Our ref: DOC20/840738-17

Your ref: SSD-10159

Response to Submissions Report – Northside Private Hospital, West Gosford (SSD-10159)

Northside Private Hospital, West Gosford (SSD-10159)

TITLE				
ON-SITE DETENTION (OSD) TANK PLAN				
SCALE	DRAWN	DESIGNED	CHECKED	APPROVED
AS SHOWN	M.T.	M.Cz.	L.S.	L.S.
JOB No.	DRAWING No.		ISSUE	
6422001		C6.04		1
DATE	STATUS			
JULY 2020	SSDA

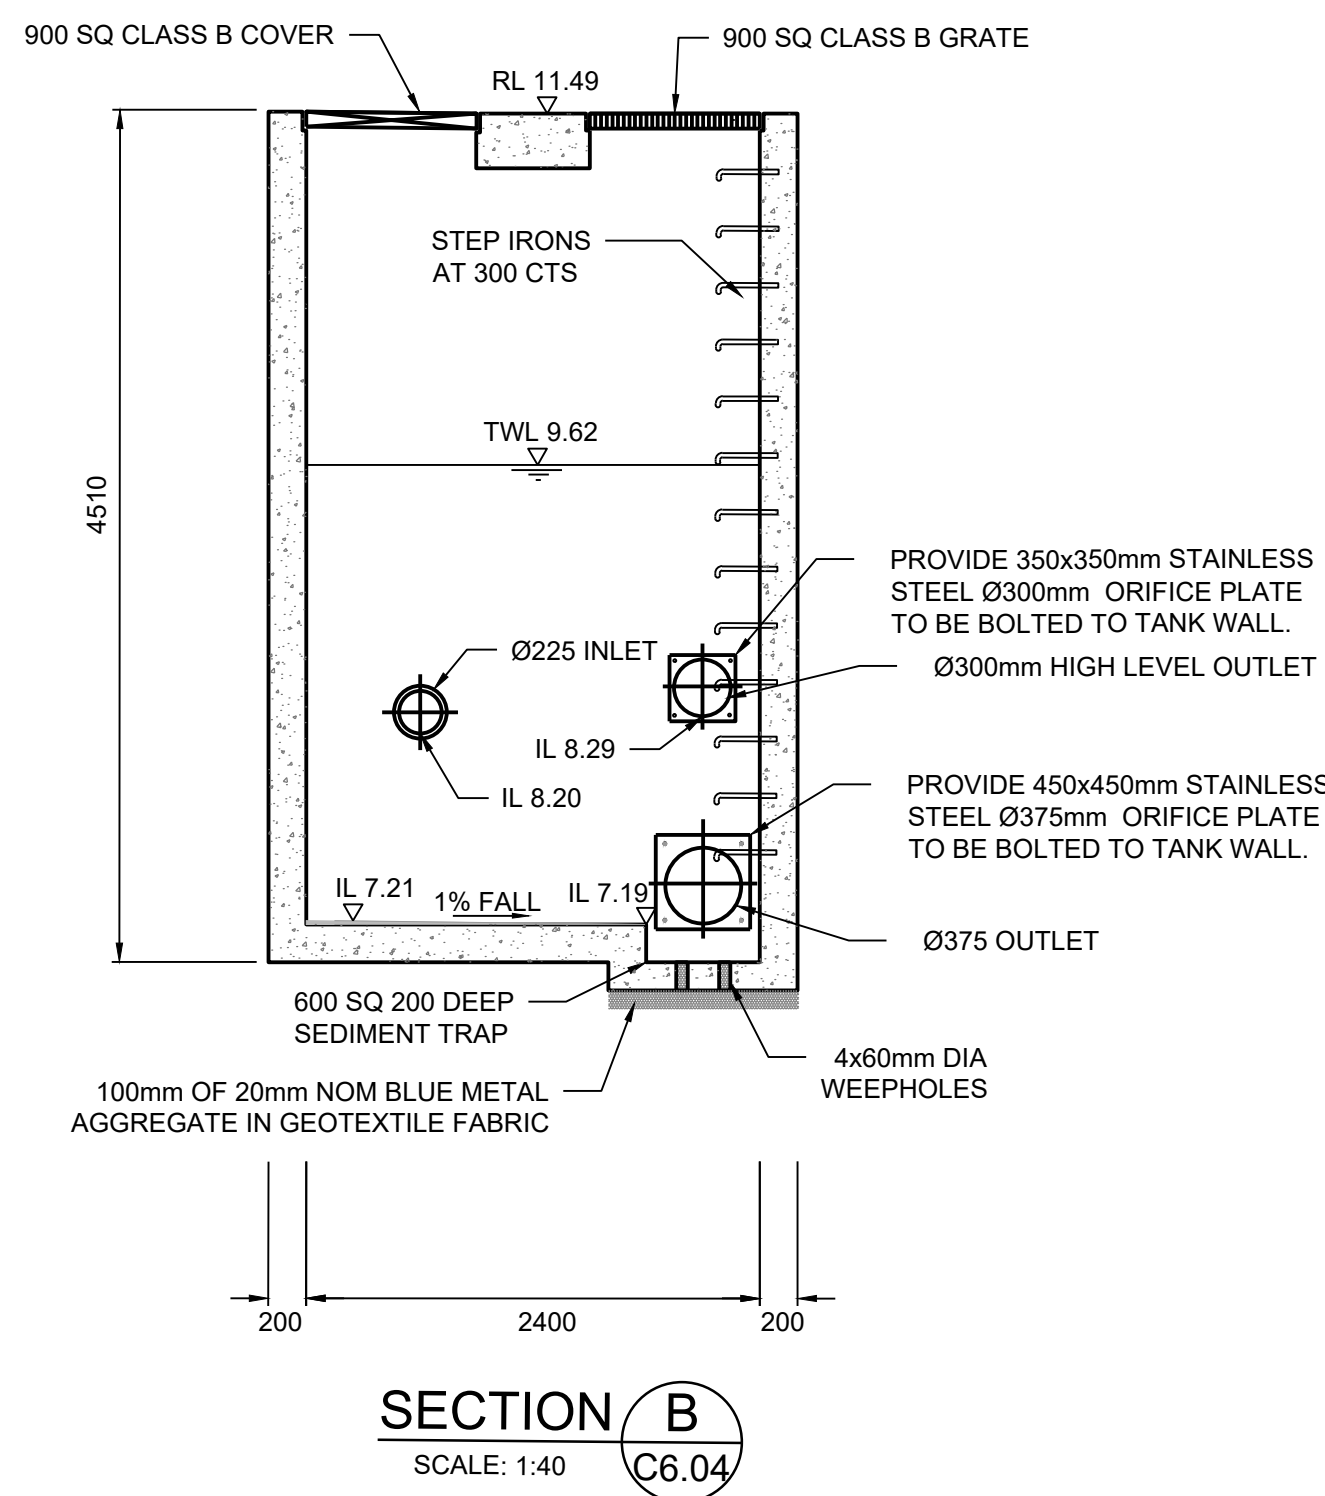
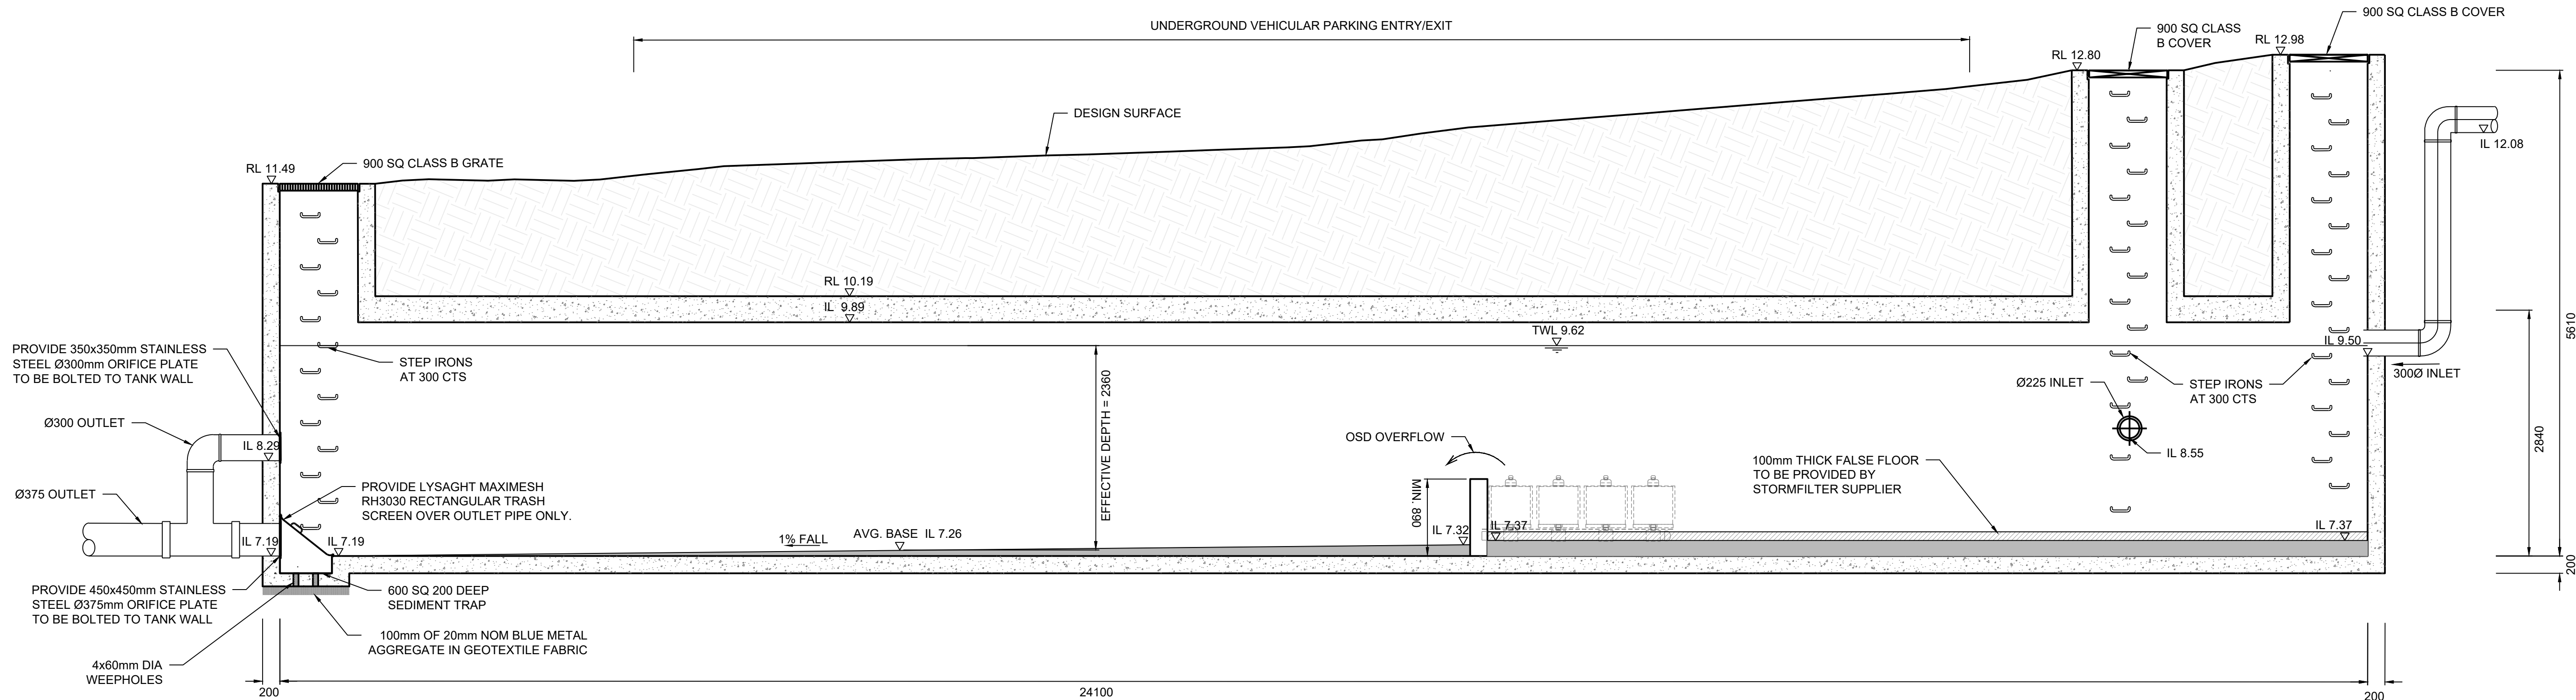
These concerns relate to the safe functioning of the on-site detention (OSD) system. The proposed hospital has two underground carparks that are lower than the OSD tank. Overflow from the OSD could flow down the access driveway and flood the basement carpark when its capacity is exceeded. This could occur in the event of a pump failure, blockage, or if Council's receiving stormwater pipe is overloaded.

The OSD does not appear to have a failsafe overflow mechanism to ensure that flows in excess of the OSD's storage capacity do not flood the basement carpark. Under predevelopment conditions, any rainfall runoff in excess of the Council's piped stormwater capacity would have previously left the site by overland flow in a distributed manner. The proposed stormwater configuration directs all site runoff to the OSD. In case the OSD fails, requirements for alarming and evacuating the basement should be considered as part of the emergency management.

Emergency management issues relating to potential flooding of the basement carpark should be adequately addressed.
